From: [REDACTED]
Sent: [REDACTED]
To: Iqraa Malik
Subject: RE: Request for further information LU/353/20/HH
Attachments: We sent you safe versions of your files; SITE PLAN.pdf

SITE PLAN 1:500 @ A4

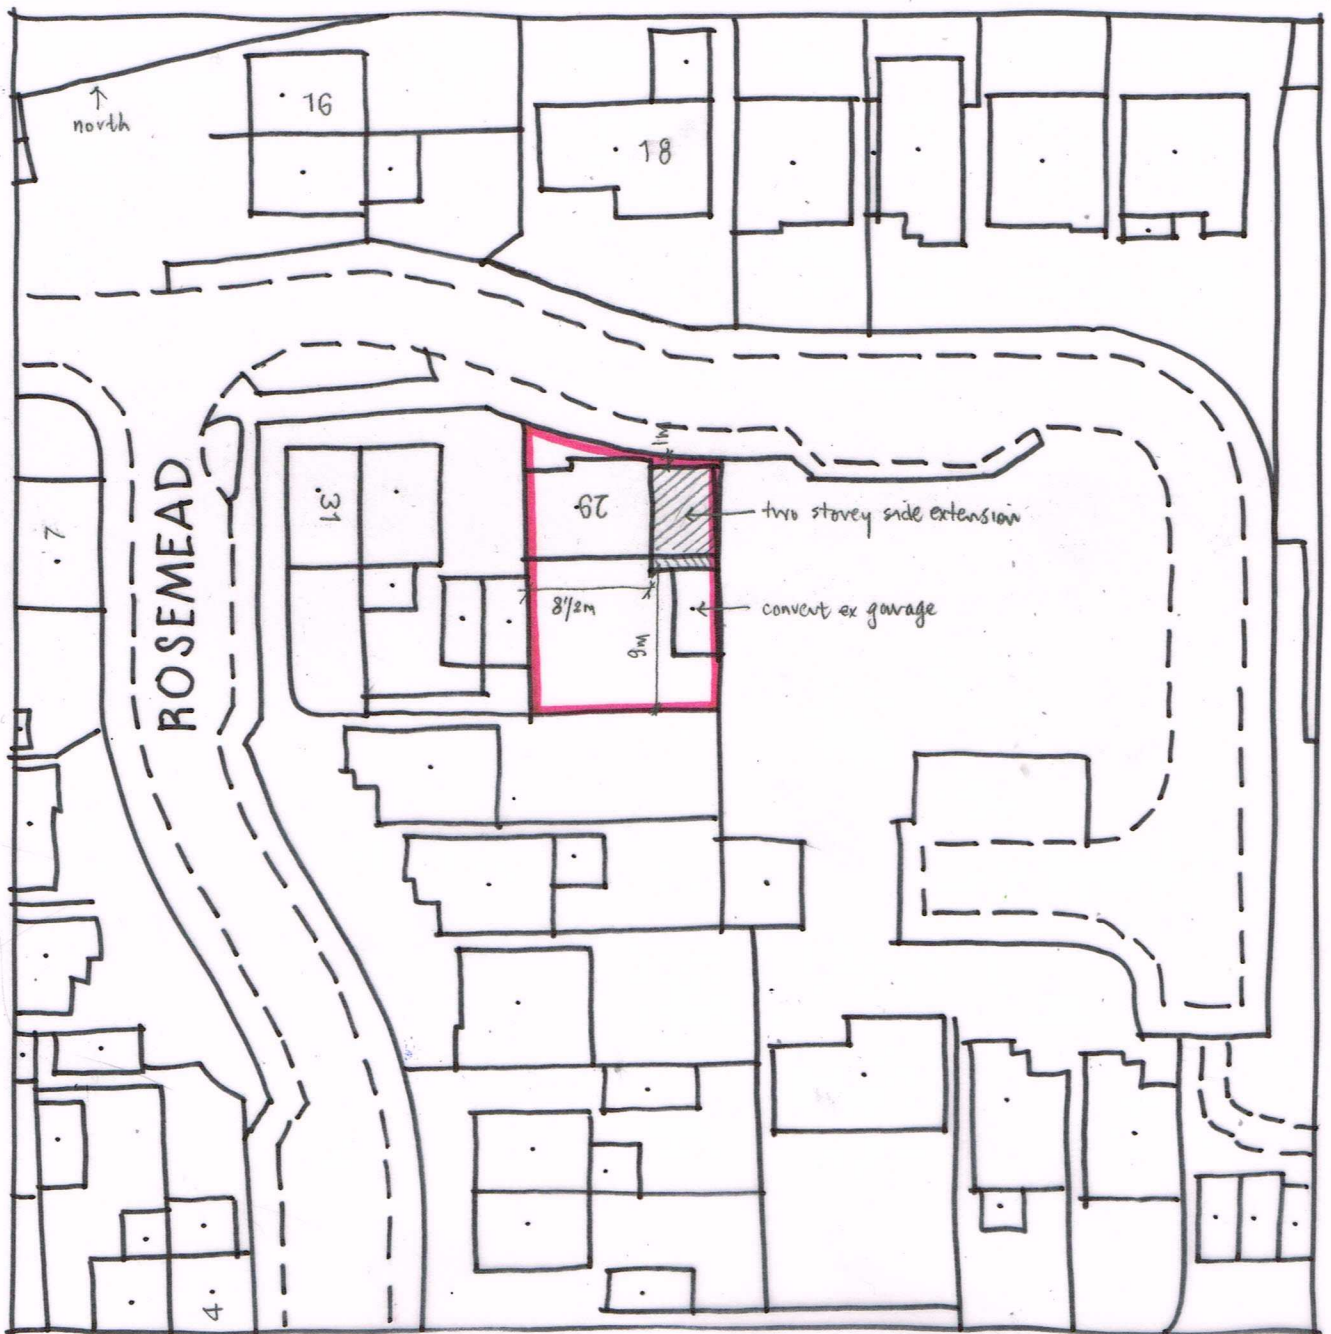
Please also add the dimension to the other side boundary.

Dimension added.
Regards and HNY.
WG
